**14/01552/F and 14/01601/LB**

**Chancel Cottage, Fir Lane, Steeple Aston**

**Internal alterations and removal of attached outbuilding to enable new extension**

Fig.29 - Proposed First Floor Plan

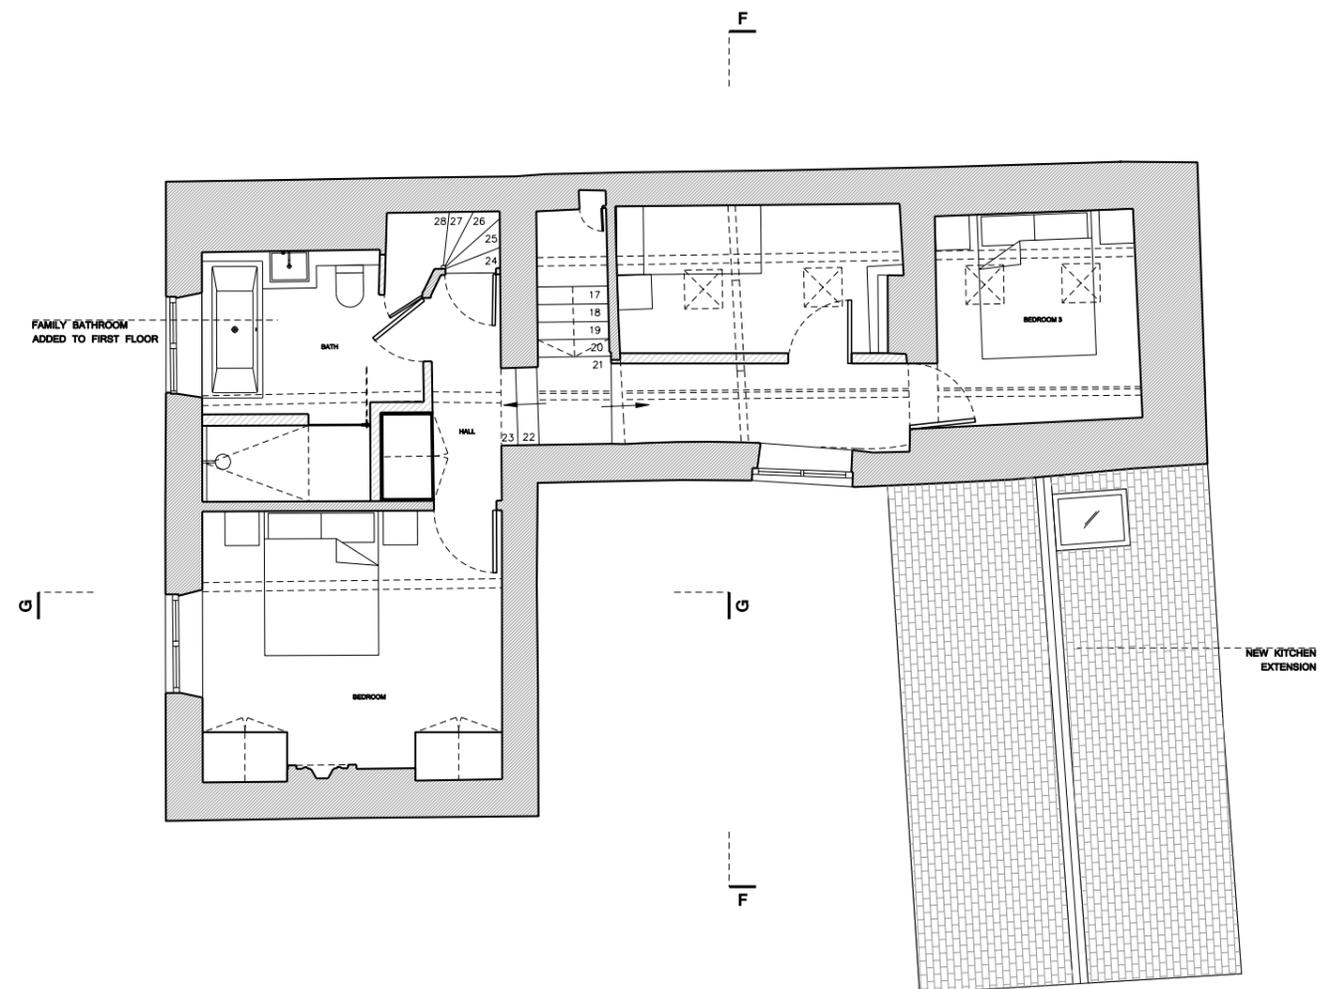
There is, however, the proposal to form an additional doorway at first floor level. The doorway is between the original stable range and the later 19<sup>th</sup> century addition, which was constructed as a physically separate structure. The ground floor area of the building has been brought into domestic usage, but the first floor area remains unconverted and unused. There is evidence of a former opening at first floor level which has since been blocked up. There would be some harm to the significance of the site if this element of the building were to be converted, but this would need to be weighed against the public benefit of bringing this section of the building into use with the associated benefits of better maintenance.

It is understood that concerns were expressed by the previous Conservation Officer relating to the provision of a bathroom at first floor level. There are no objections in principle to a bathroom at first floor level, but it is vital to ascertain the details of the proposal and how this will be achieved

without causing harm to the building. Further details are required about whether or not obscure glazing is required (this would be considered to cause harm if on the front elevation of the building) and the location and dimensions of any proposed waste pipes. This will enable a detailed assessment to be made of the harm versus the public benefit.

Dormers are not a characteristic element of simple, vernacular cottages such as this one and will have an aggrandising effect at the rear of the property. There are no objections to the use of the space and an existing stairway leads up to the attic level. The proposal for roof lights, which are flush to the roof is a compromise which allows light into the space. It should be clear, however, that if further alterations are required to enable the space to be used as a bedroom due to building control requirements these may not be forthcoming. The property could function as a three bedroomed family home with additional, ancillary space to be used as office, study or playroom. The proposed dormers are considered to cause harm to the significance of the historic building and the public benefits are not considered to outweigh this harm.

Chancel Cottage - Proposed West Elevation

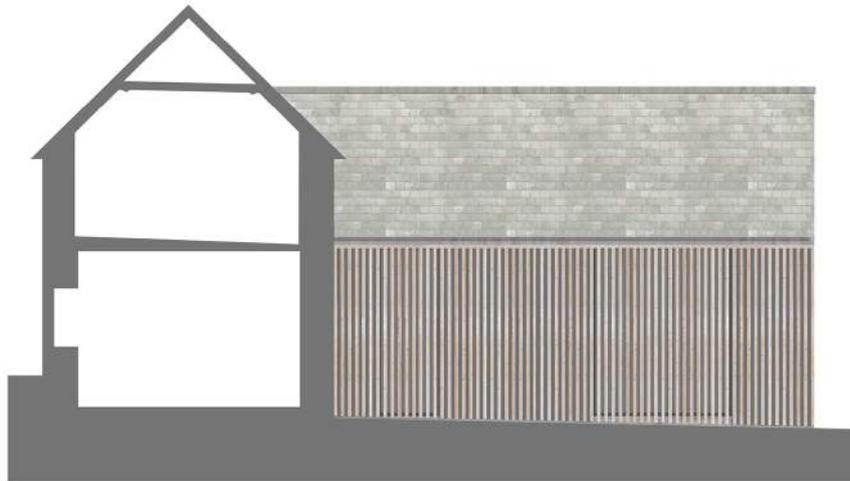
There are significant concerns with the use of timber boarding in this context. The use of timber or weather-boarding appears to be the latest 'trend' in the district, but does not have historic precedent in the locality. Weather-boarding is historically reserved for detached outbuildings or specific functions in relation to canal side buildings and mill buildings. The proposed extension is not an outbuilding, but a large extension which is physically joined to the property. There are also long term maintenance concerns, particularly with untreated timbers whereby there can be varied

weathering depending on localised conditions. It is important to consider the visual appearance and maintenance issues for the property in the medium to long term. The proposed use of timber boarding on an extension (as opposed to outbuilding) is considered to cause harm to the character and appearance of the conservation area and the setting of the listed building. There is not perceived to be any public benefit to outweigh this harm.
